Application for a non-material amendment following a grant of planning permission.

Number	
Suffix	
Property name	Sunny Corner
Address line 1	Copse Lane
Address line 2	
Address line 3	
Town/city	Walberton
Postcode	BN18 0QH
Description of site location must be completed if postcode is not known:	
Easting (x)	496503
Northing (y)	106526
Description

9 No. dwellings with associated car parking, bin storage & landscaping & creation of new access road from existing access onto West Walberton Lane. This application is a Departure from the Development Plan

Reference number:	APP/C3810/W/18/3210153
Date of decision	06/06/2019

Client	Driftstone Homes Ltd				
Job title	Development at Sunny Corner, Copese Lane, Walberton, West Sussex, BN18 0QH				
Drawing title	Plot 1 --: Plans & Elevations				
Drawn KP	Date 06.07.17	Checked	Date	Scale at A1 1:100	
Job No. 17-025	Drawing No. SCR-MHA-00-XX-DR-A-	Rev.			P7
Purpose of Issue

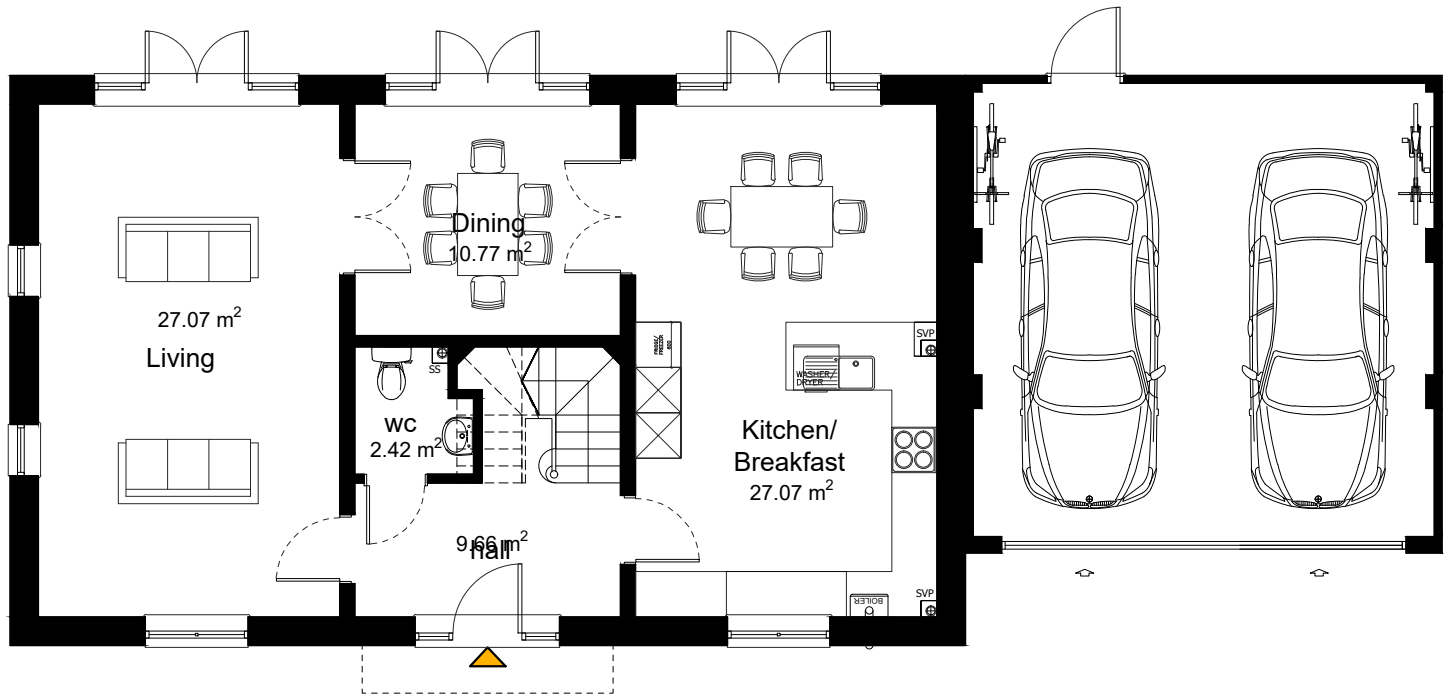
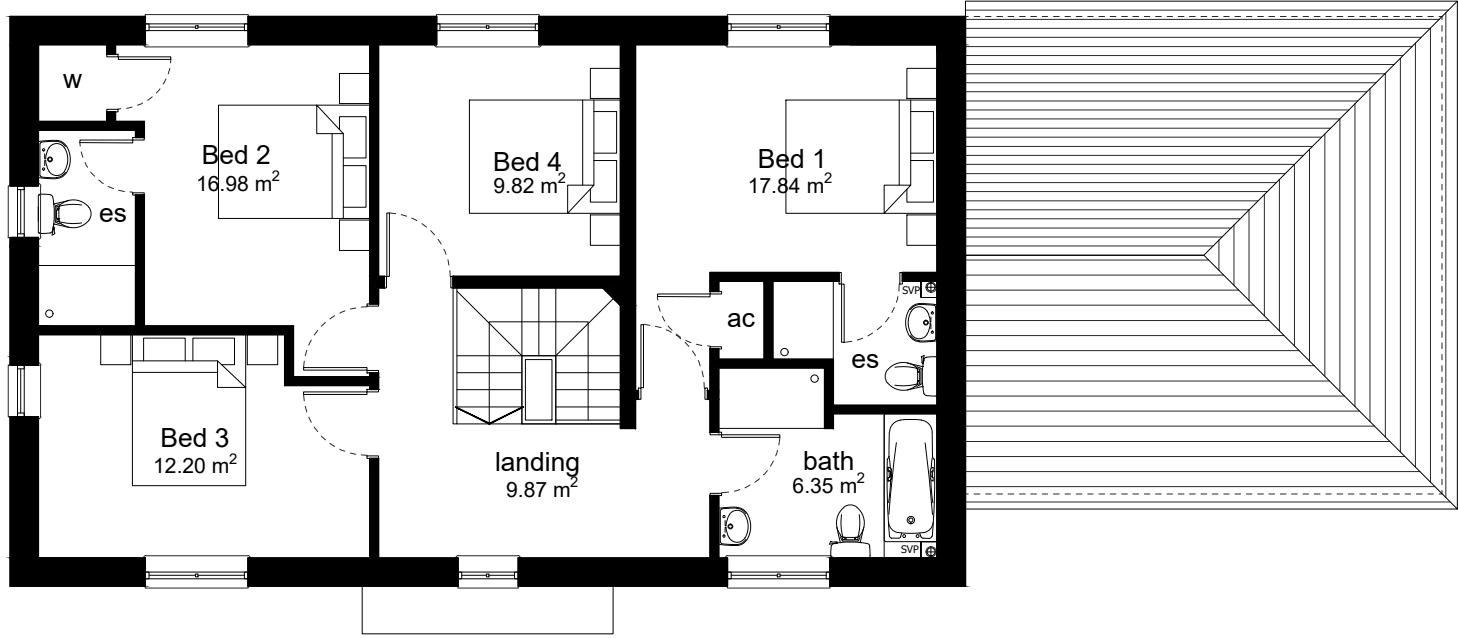
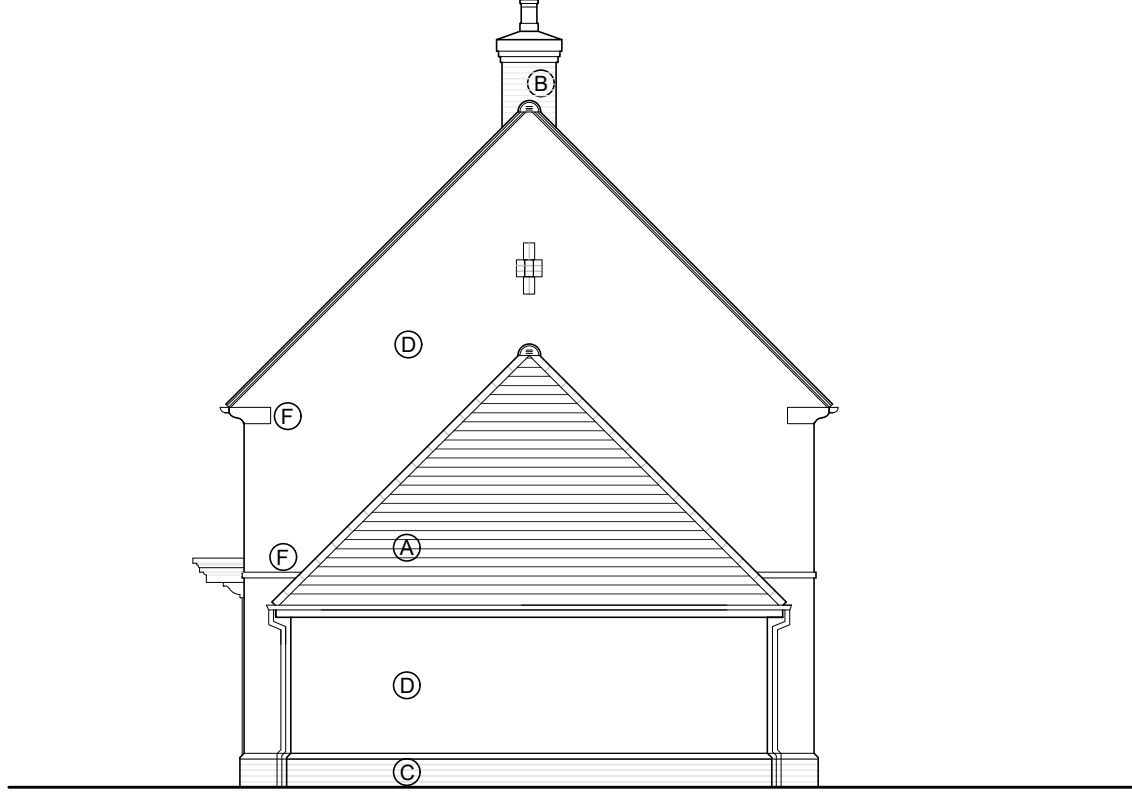
PLOT 1 - Alteration of chimney; replace bifold doors to rear with French doors and sidelights

17-025/0010 REV P6 - Plot 1

Plot 2
-:-
Plans & Elevations

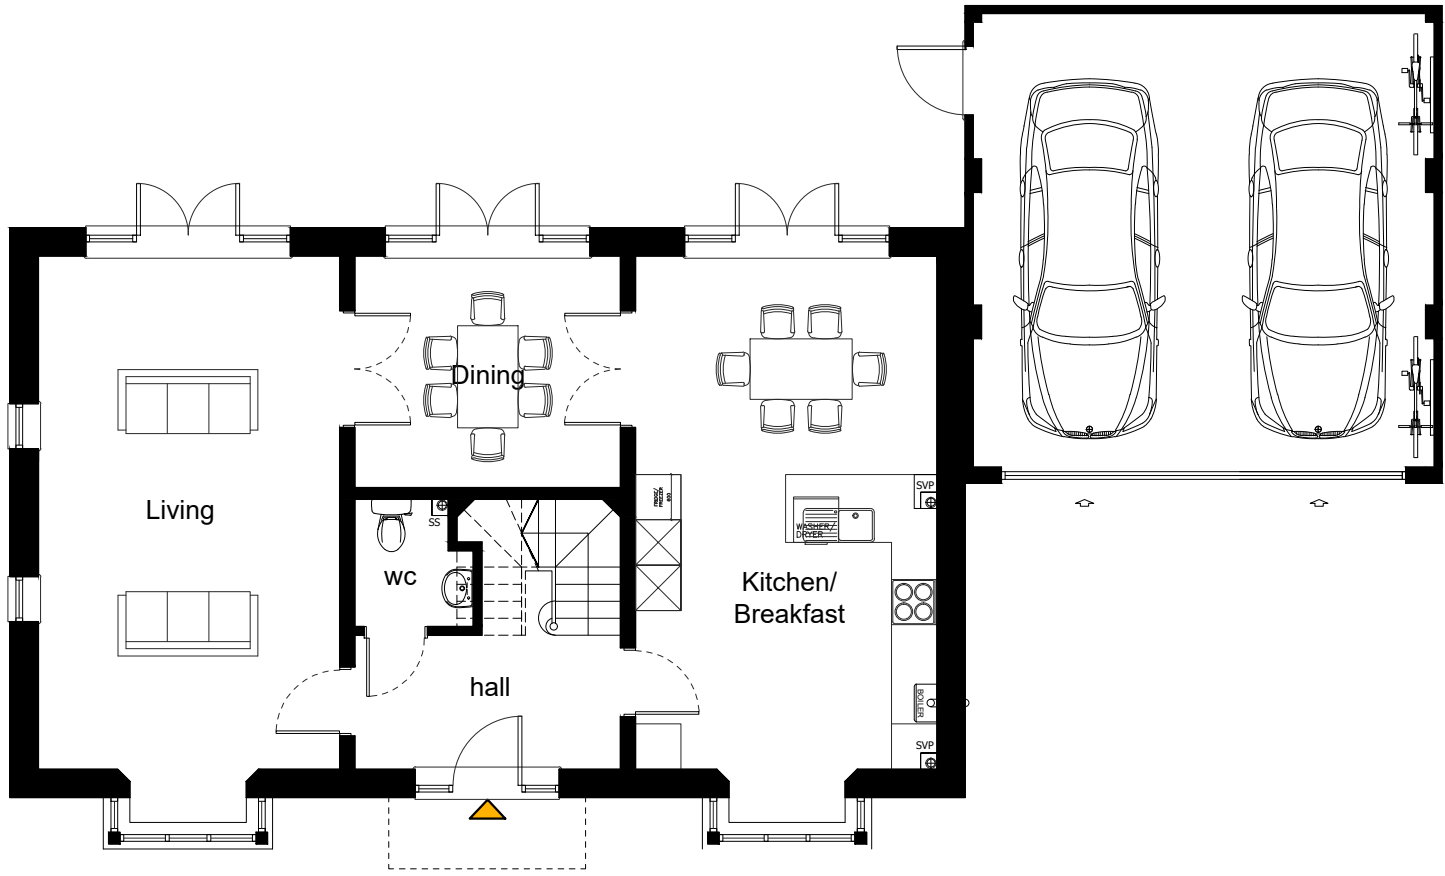
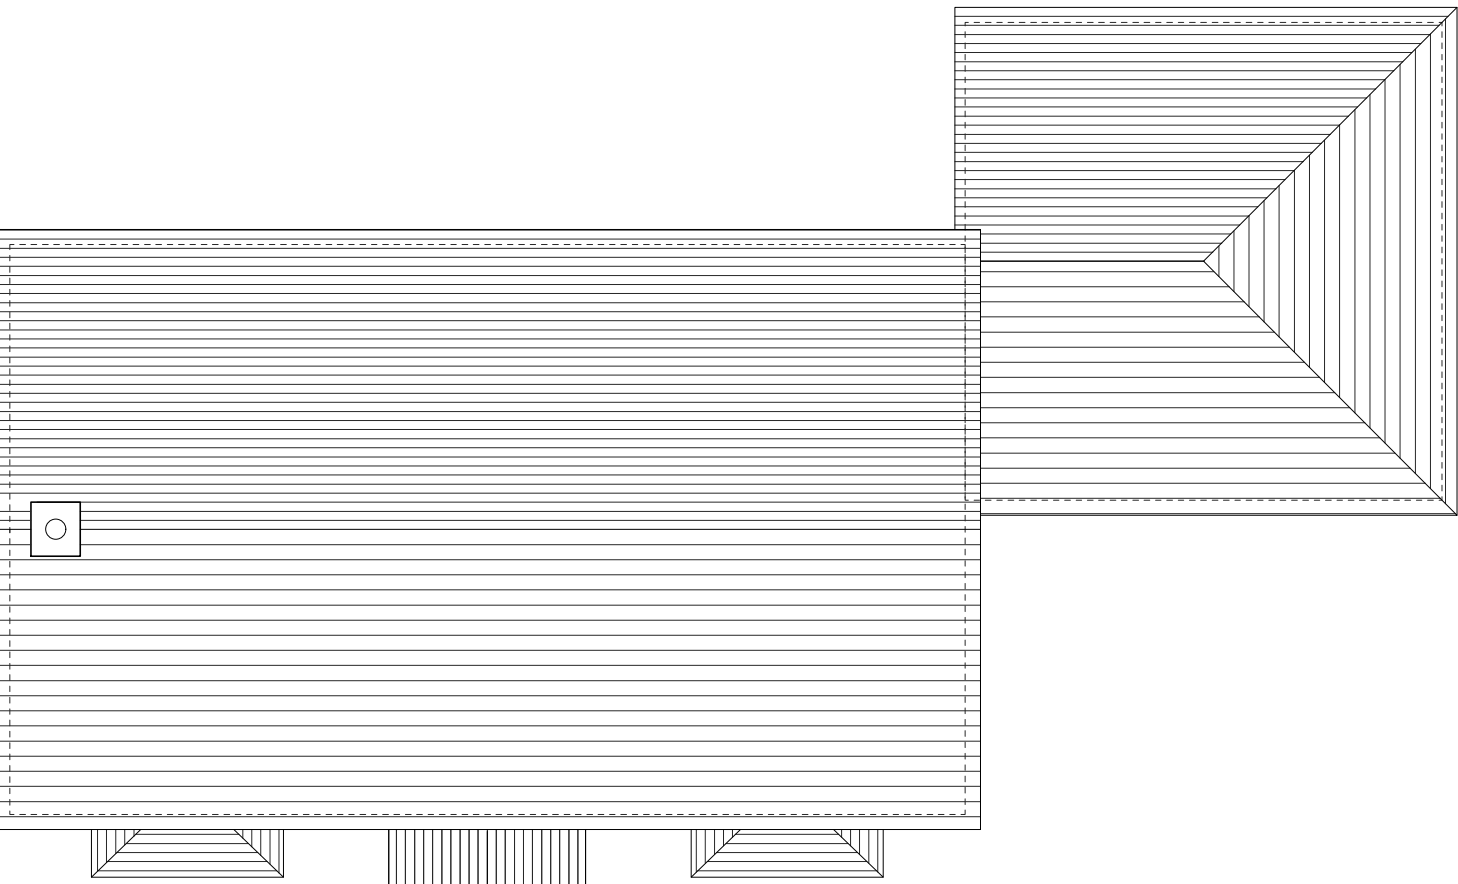
PLOT 2 - Alteration of chimney; replace bifold doors to rear with French doors and sidelights

17-025/0011 REV P6 - Plot 2

Plot 6
-:-
Plans & Elevations

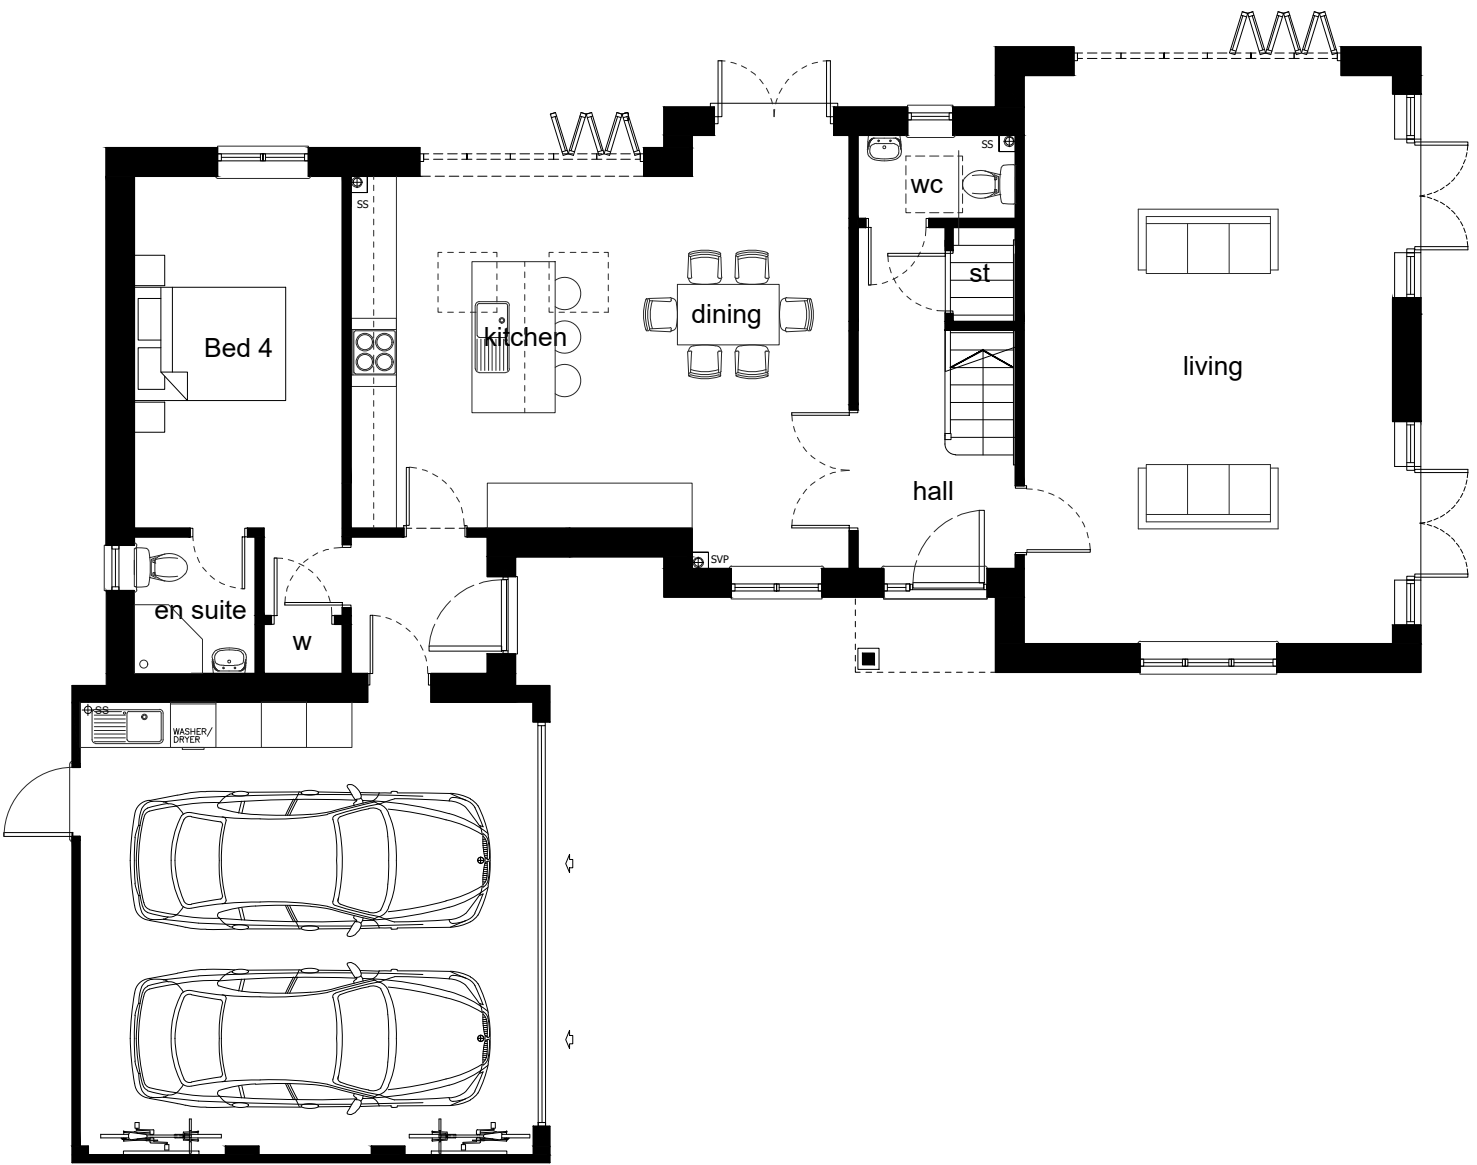
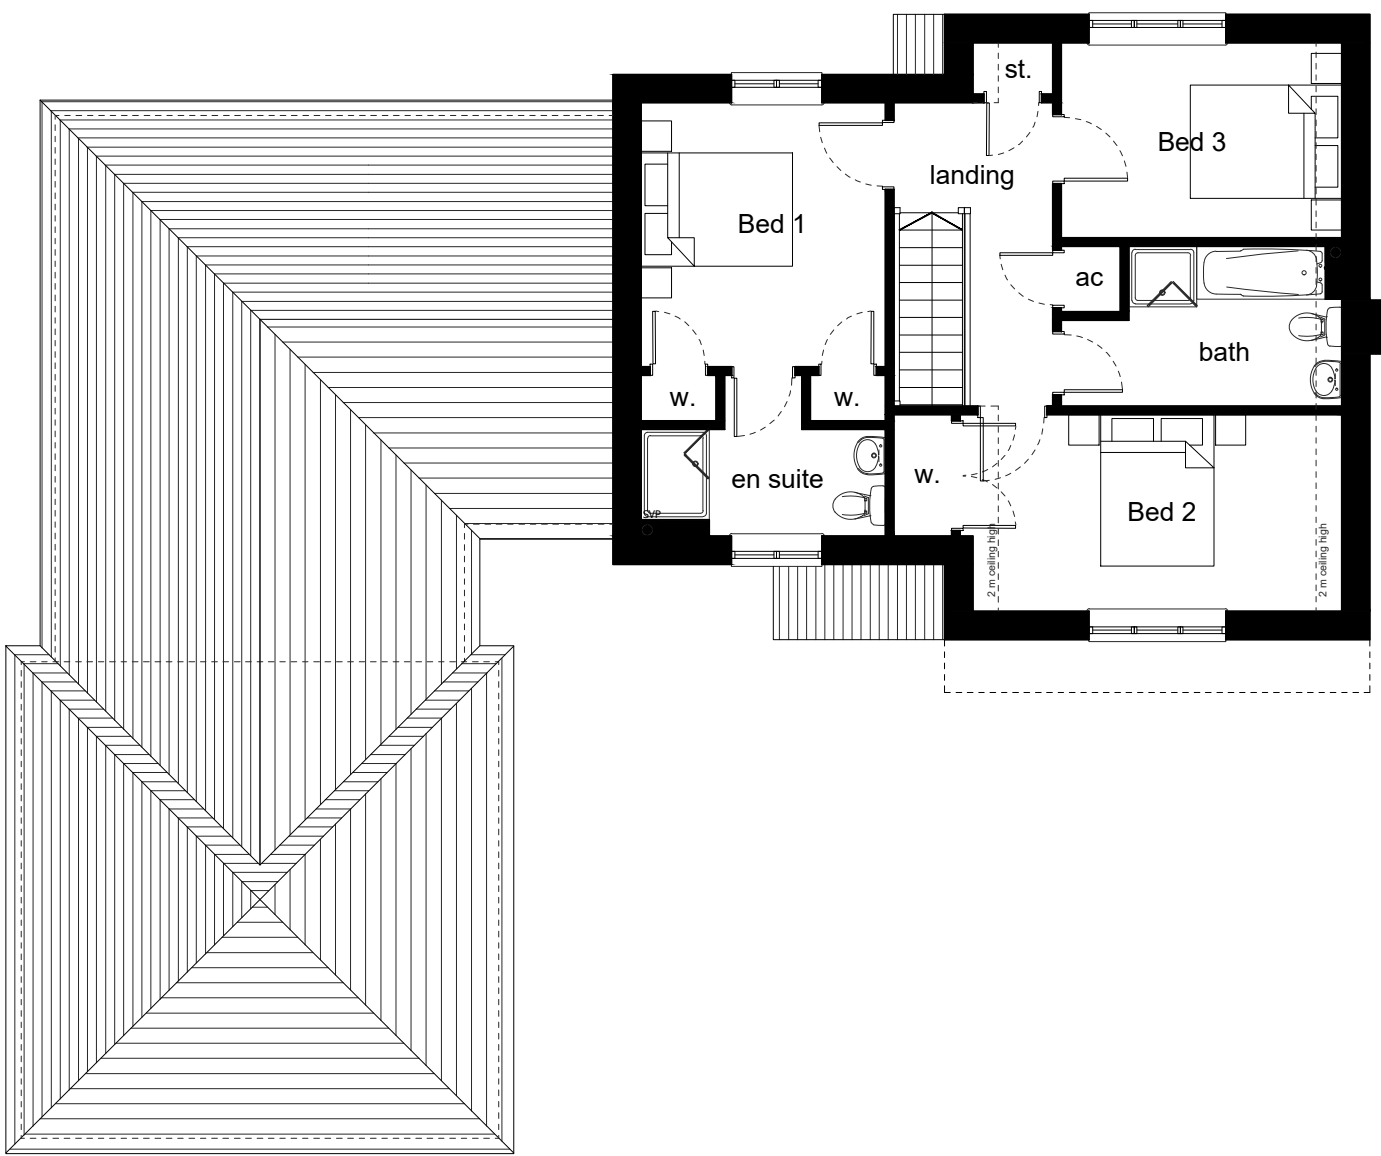
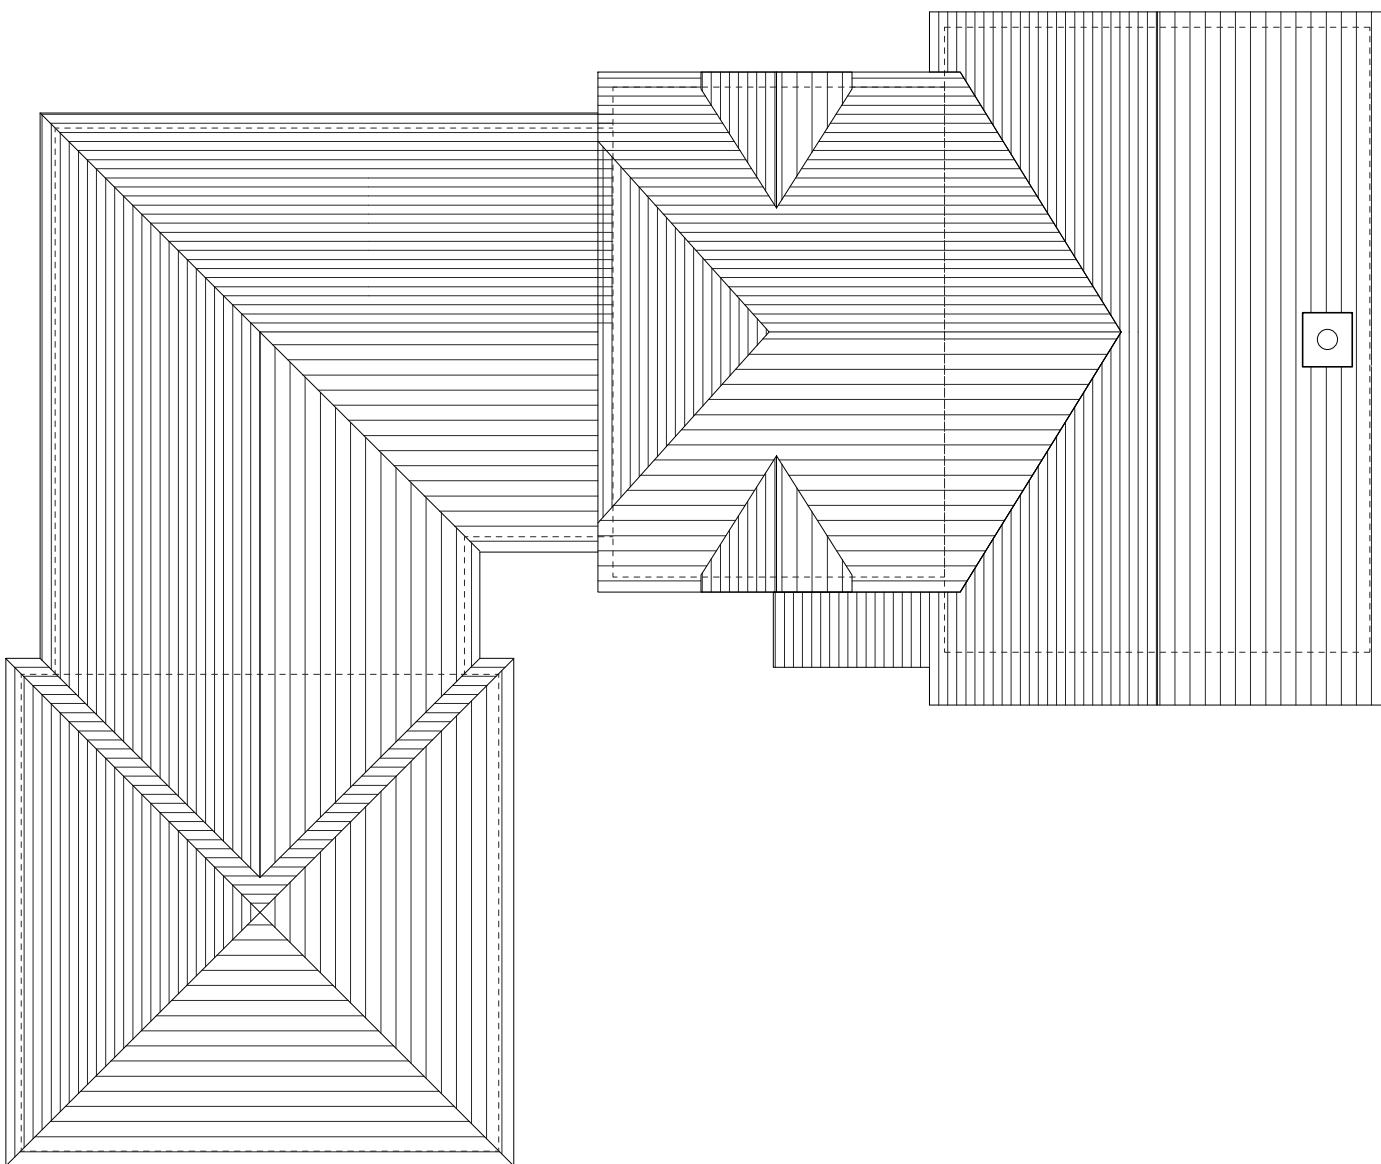
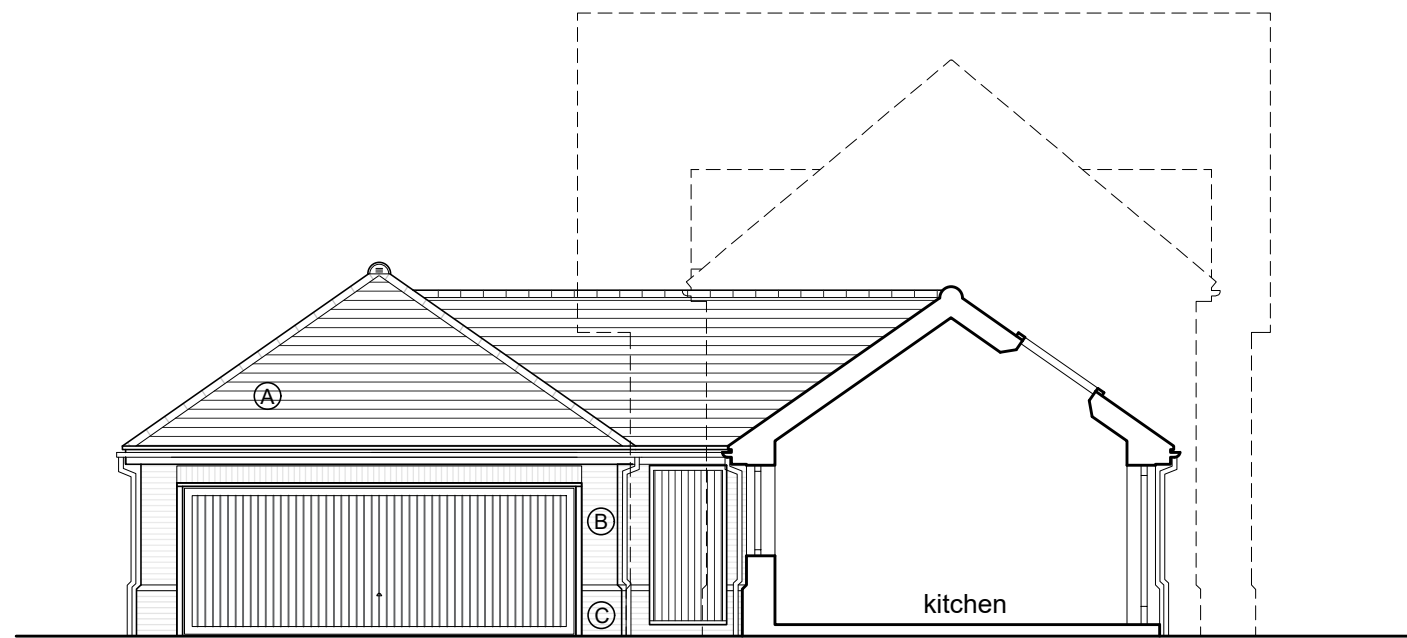
PLOT 6 - Alteration of chimney; replace French doors to side elevation with a window; omission of single casement window from front elevation/kitchen

17-025/0014 REV P9 - Plot 6
